**From:** [REDACTED]  
**To:** [M25 Junction 28](#)  
**Cc:** [REDACTED]  
**Subject:** London Borough of Havering Deadline 5 Submission TR010029 -Response to Applicant's response to LB Havering's Deadline 3b submission (REP4-010)  
**Date:** 13 April 2021 19:58:47  
**Attachments:** [LBHaveringResponsetoREP4-010 - 13042021.pdf](#)

Please find attached the London Borough of Havering (20025659) submission for Deadline 5 for the M25/J28 Improvement Scheme (TR010029). This submission concerns LB Havering's response to the Applicant's response to LB Havering's Deadline 3b submission (REP4-010).

**London Borough of Havering (20025659) – Response to Applicant’s responses to LBH Deadline 3B Submission (REP4-010)**

#### 9.59 Overlay plan of Plot 1/8 and the burial plots

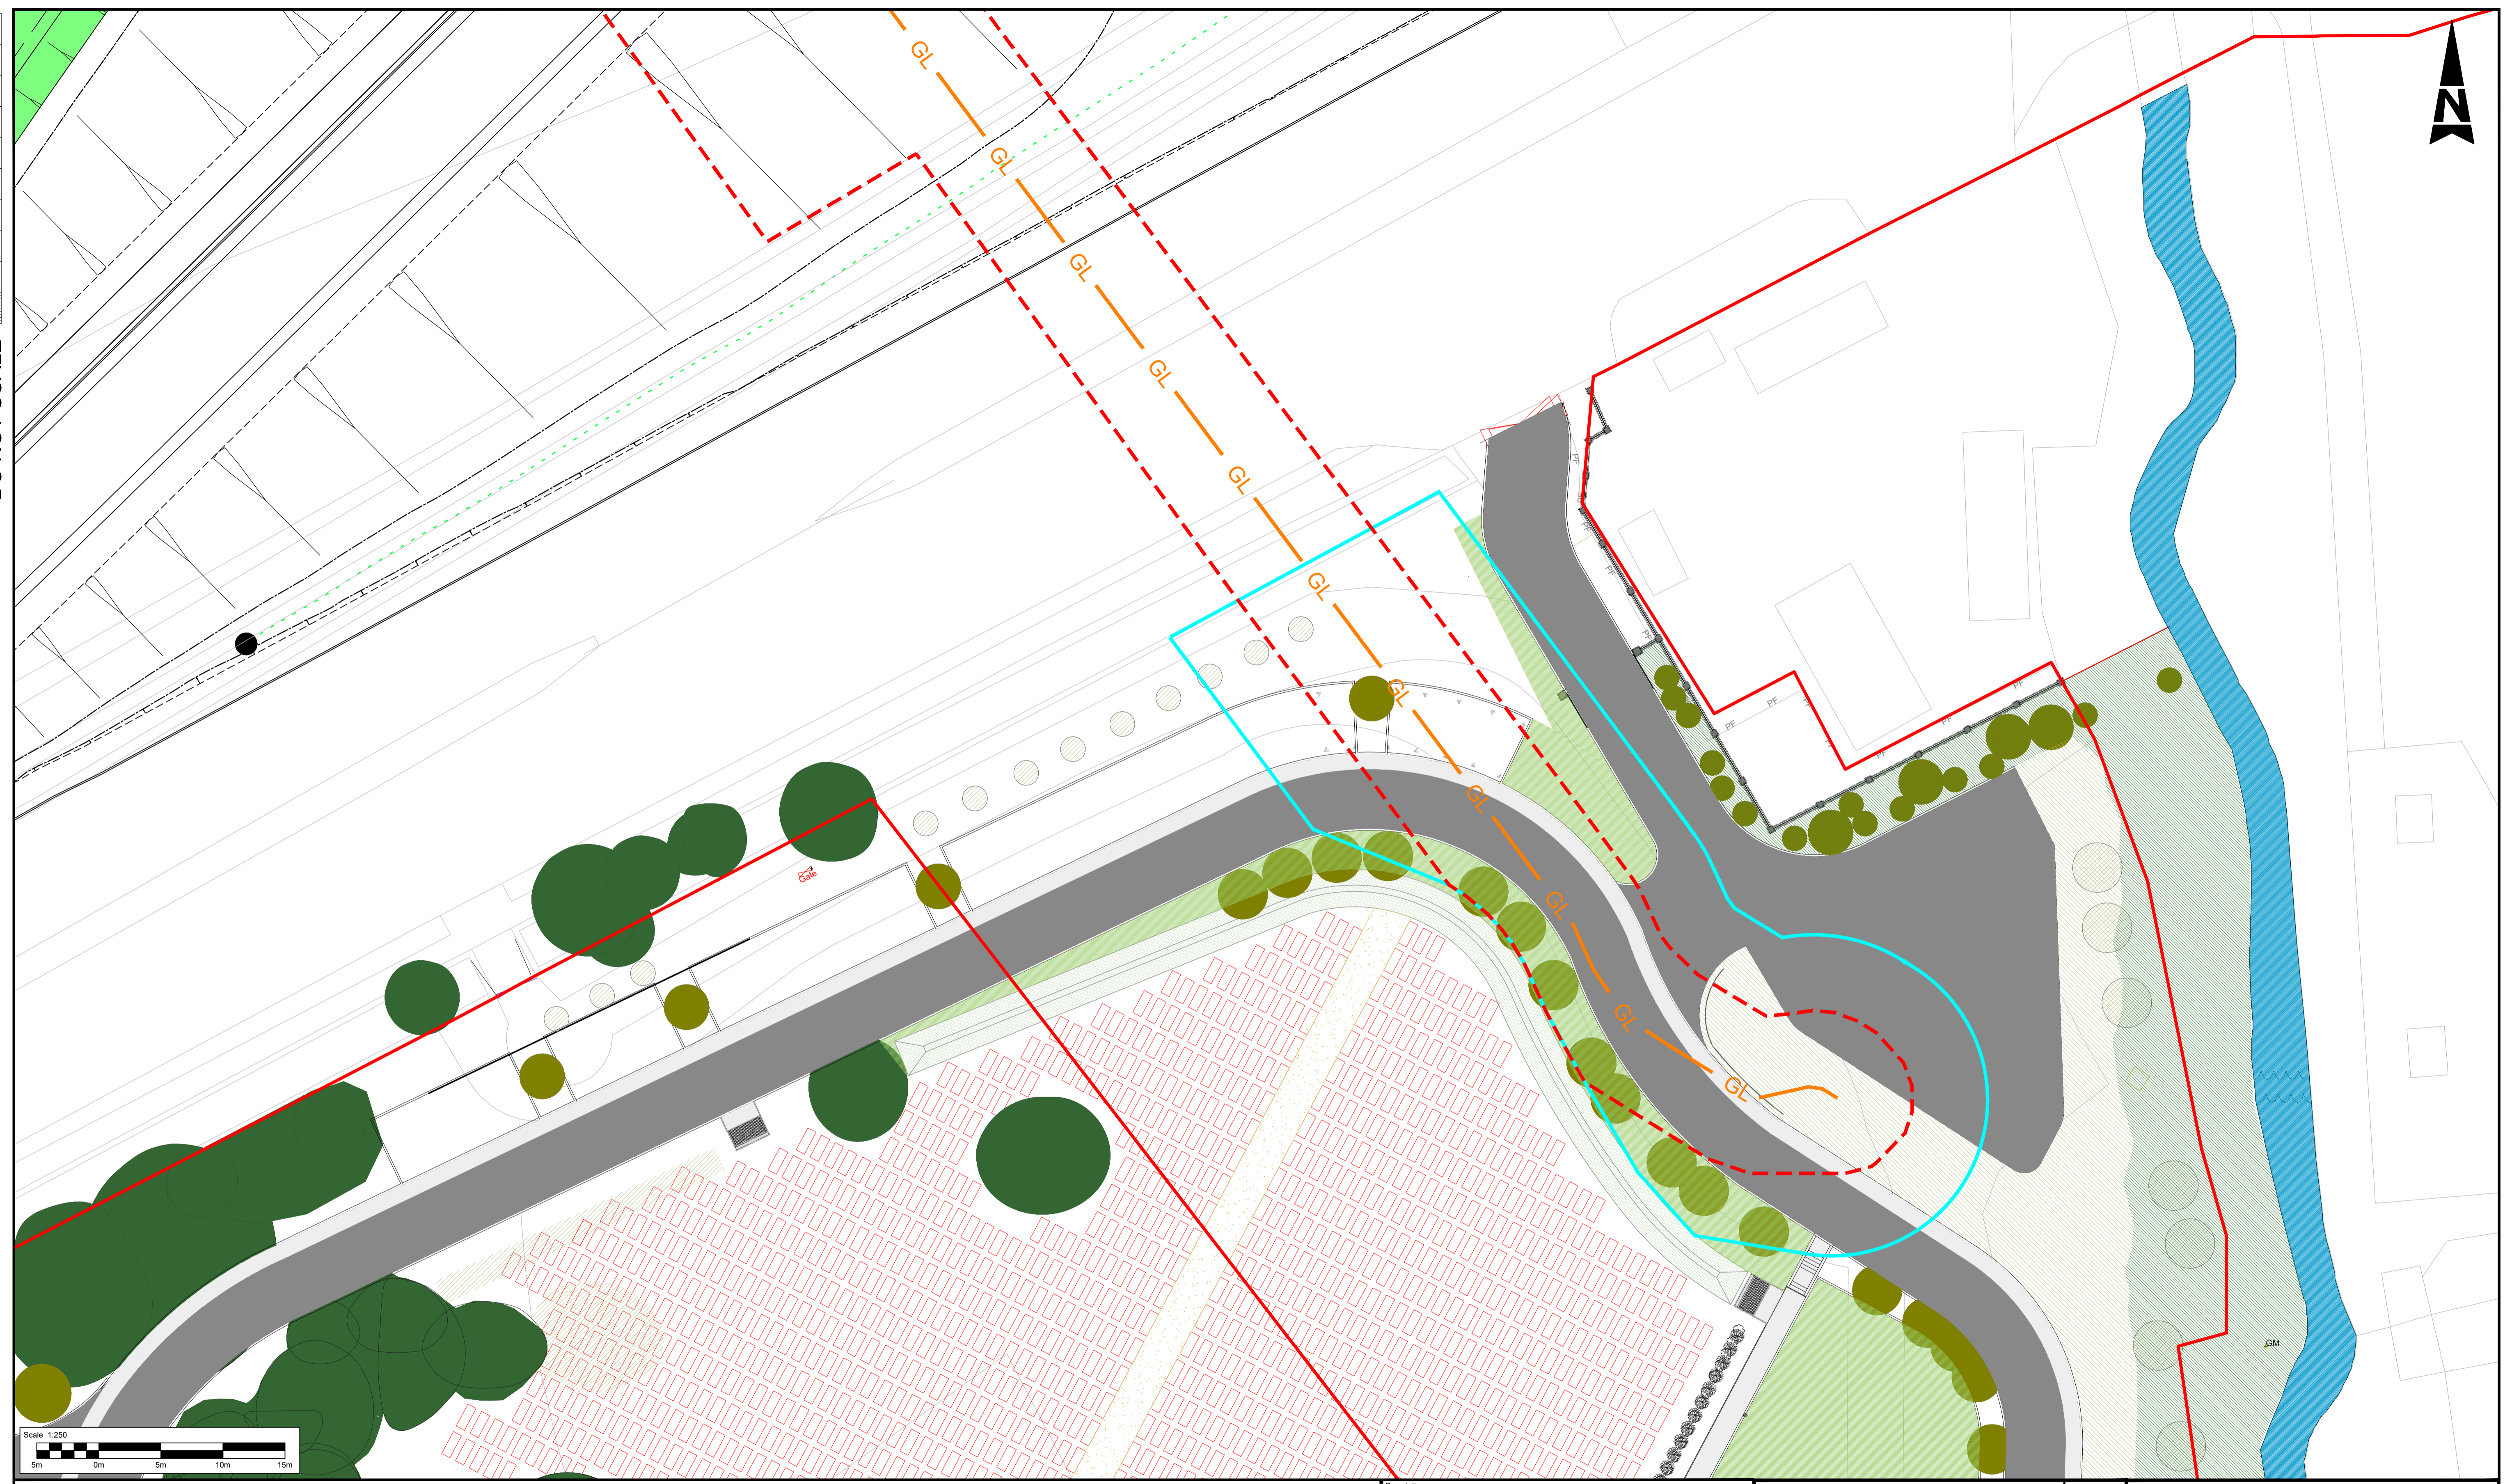
LB Havering notes that the Applicant has submitted at Deadline 4 (REP4-020) an Overlay of Works Plan showing Plot 1/8 and the burial plots at the Gardens of Peace Cemetery. It is further noted that draft Heads of Terms have been sent to the Gardens of Peace Trustees. Should the Trustees be satisfied with the information provided, LB Havering would consider that the scheme is in compliance with LDF policies CP8 and DC27.
